From: Sue Howell
Sent: 21 April 2015 17:11
To: Planning.Responses
Cc: Neil Crowther
Subject: RE: Planning Consultation on: A/23/15/OUT

Comments from Greenspace:

APPLICATION **A/23/15/OUT**

Description of Works: Hybrid application - Full Planning Permission for
 a retail unit (Class A1) comprising 1,487sqm
 (1022sqm ground floor and 465sqm mezzanine)
 with associated access, car parking, servicing,
 landscaping & associated works.
 Outline Planning Permission for a public house
 (Class A4) comprising 581sqm at ground floor
 level.

| Drawing Number<br>1117-P-11 | Revision<br>E    |

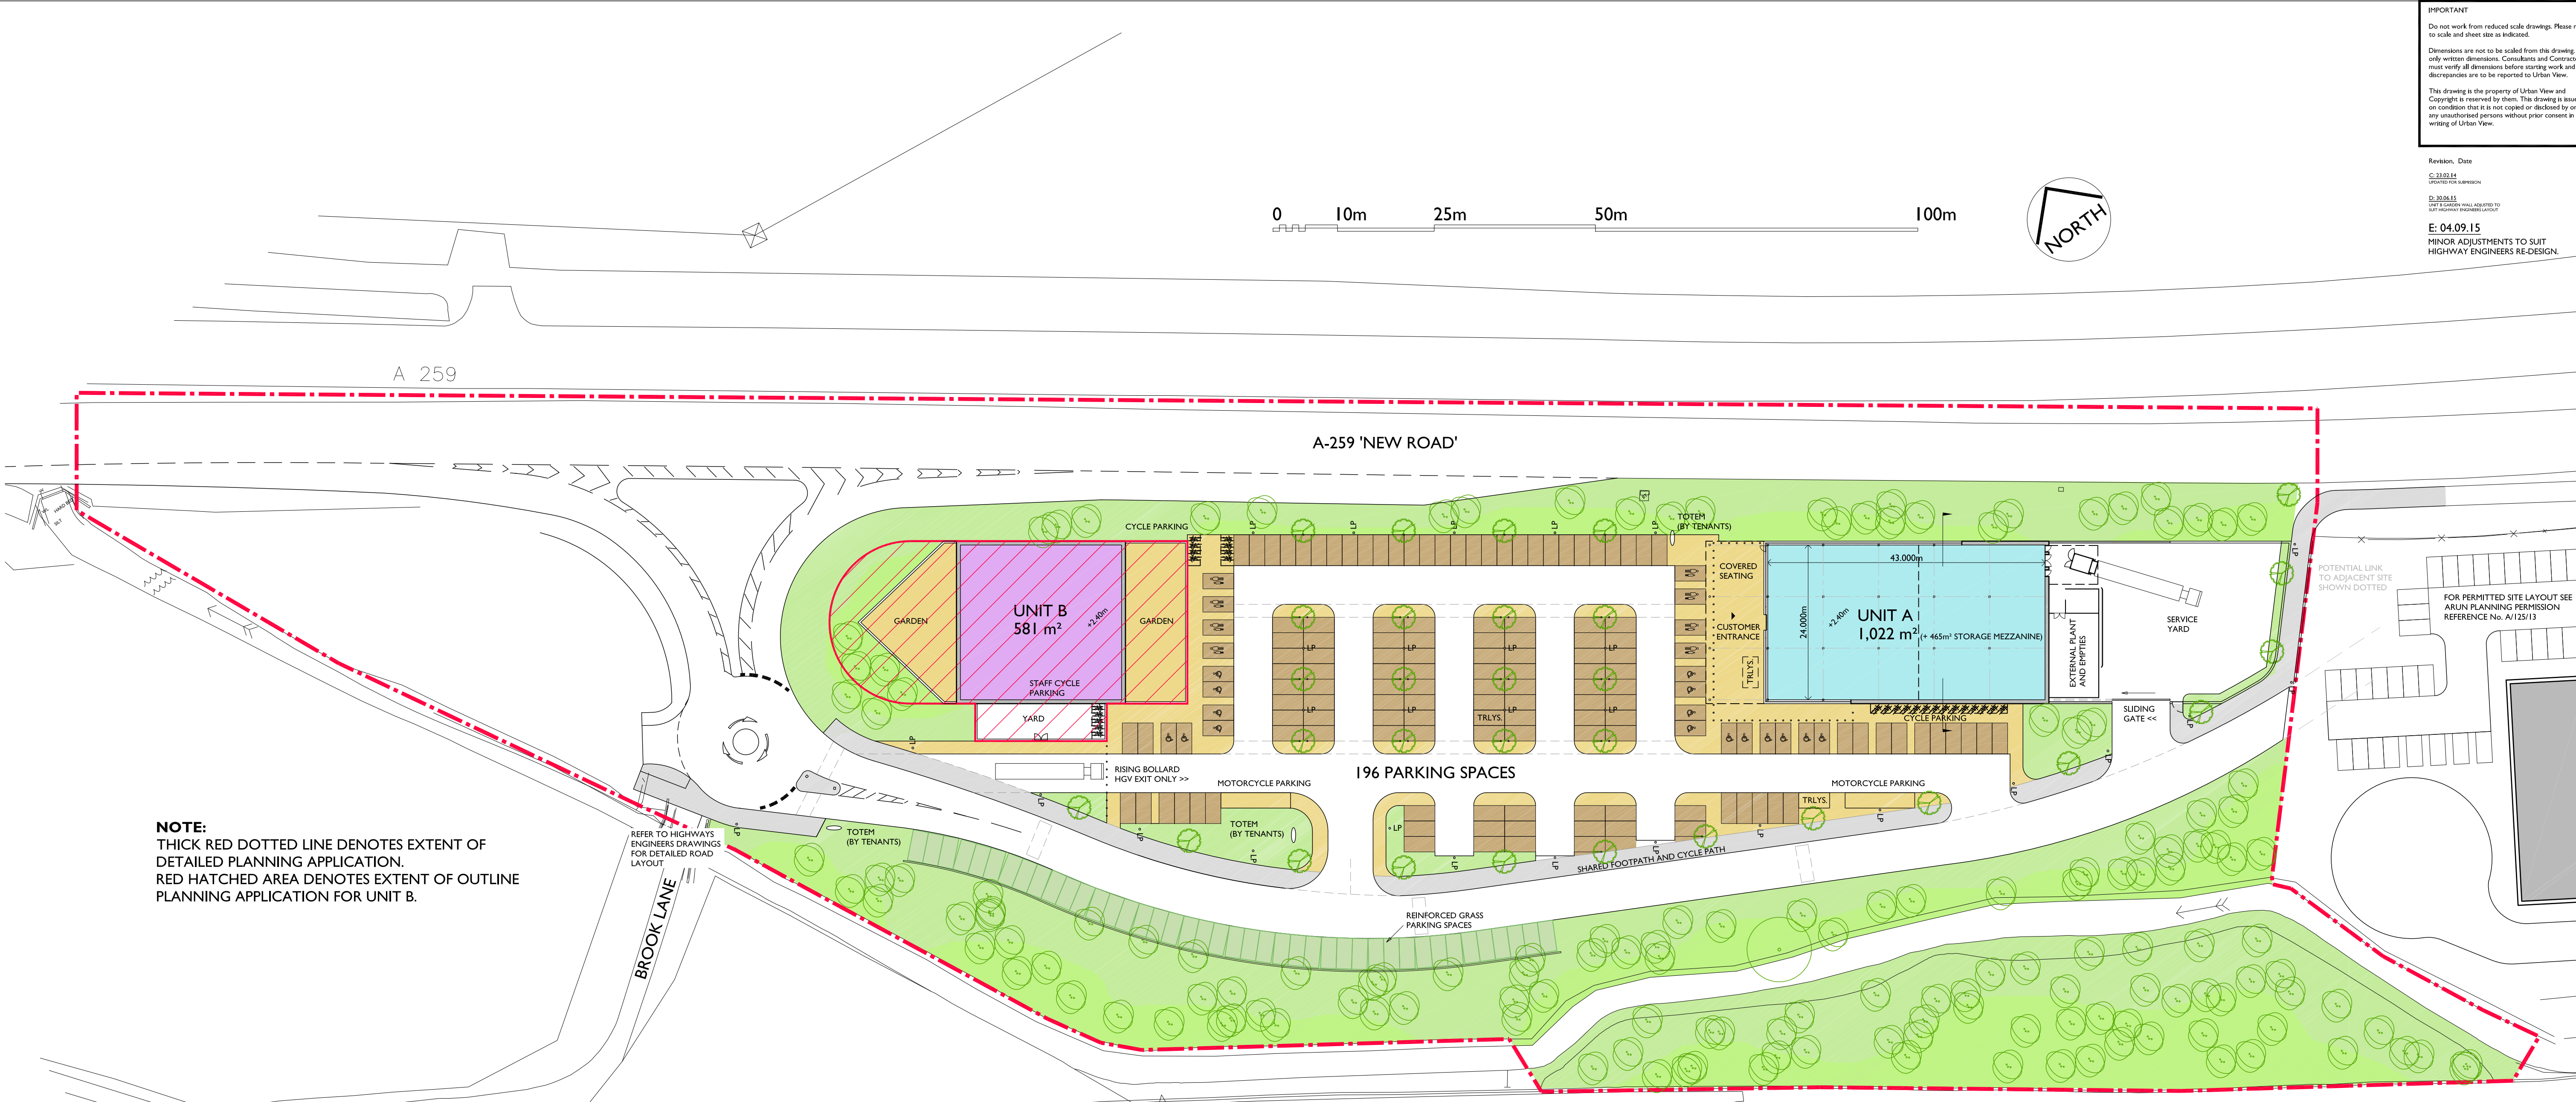
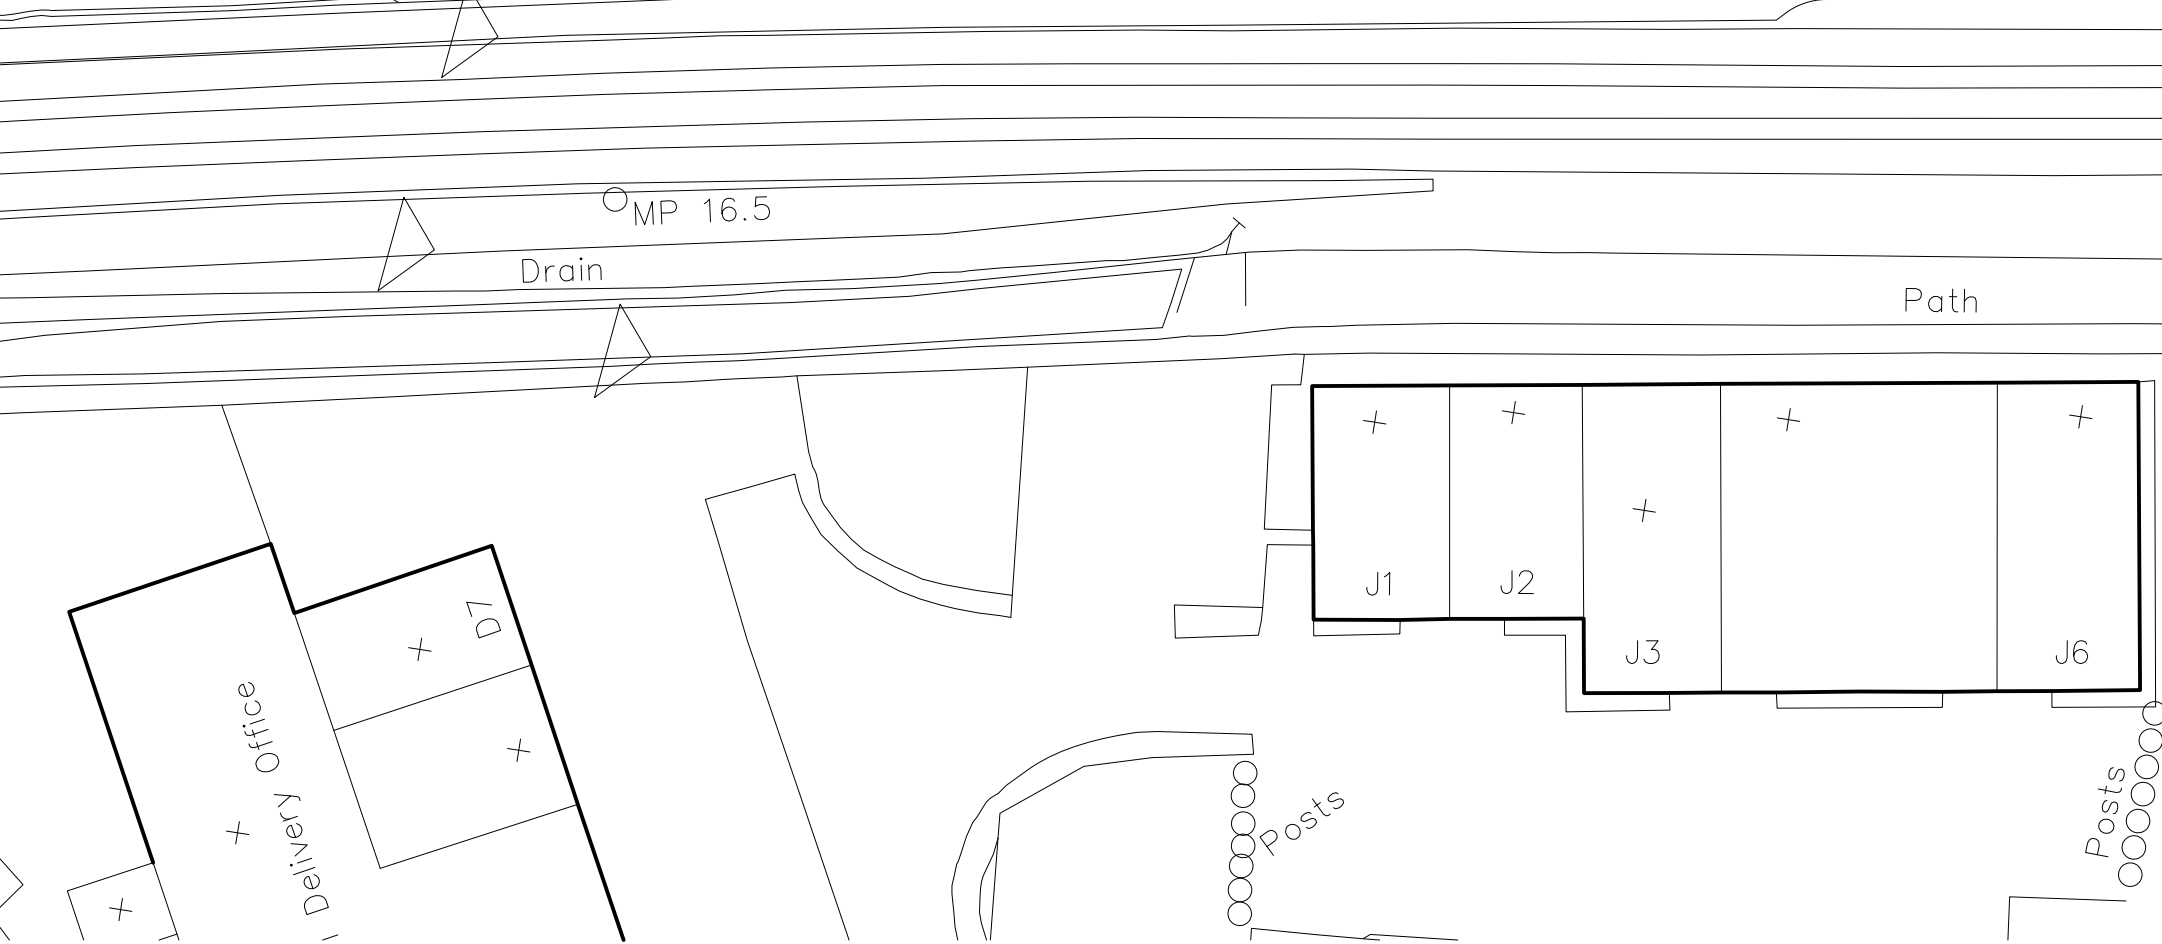
Landscape drawings 1117-P-11 Rev C and KL.264.001 Rev C show indicative schemes, which whilst show a comprehensive mix are only an indicative layout. Plans would be required that detail a full landscape scheme submitted for approval. These would need to detail species choice, position, densities and size at time of planting. These should be plotted in plan and list form and in relation to the trees and vegetation to be retained so that a clear picture of the proposals can be seen. These details are required to ensure that appropriate screening is provided, maintaining and uncompromising the setting and ensuring that the proposals fit within the area of neighbouring development and properties and neighbouring South Downs National Park, whilst benefiting the potential of the proposed developments usage.
